Your ref:
Our ref: 24/00375/F
Please ask for: Amy Davies
Direct dial: 01553 616879
E-mail: borough.planning@west-norfolk.gov.uk

Details: **First floor extensions to existing two storey dwelling. at 8A Jermyn Road
King's Lynn Norfolk PE30 4AD**

I have received a planning application as detailed above but cannot process it until I receive some more information:

FIRST FLOOR PLAN  
AS EXISTING

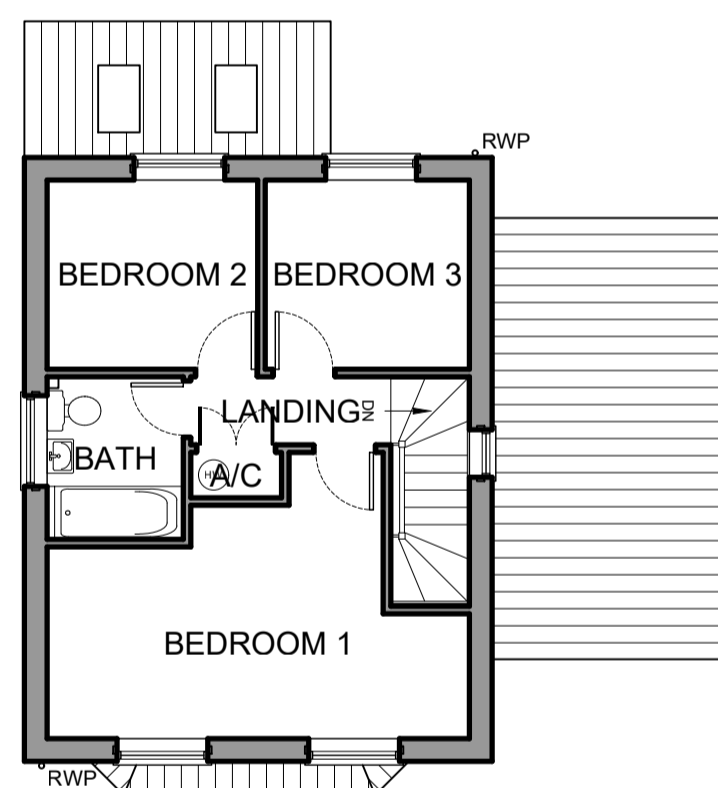
1. Please provide existing first floor plan to a scale of 1:50 or 1:100.
2. Please provide proposed ground floor plans to a scale of 1:50 or 1:100
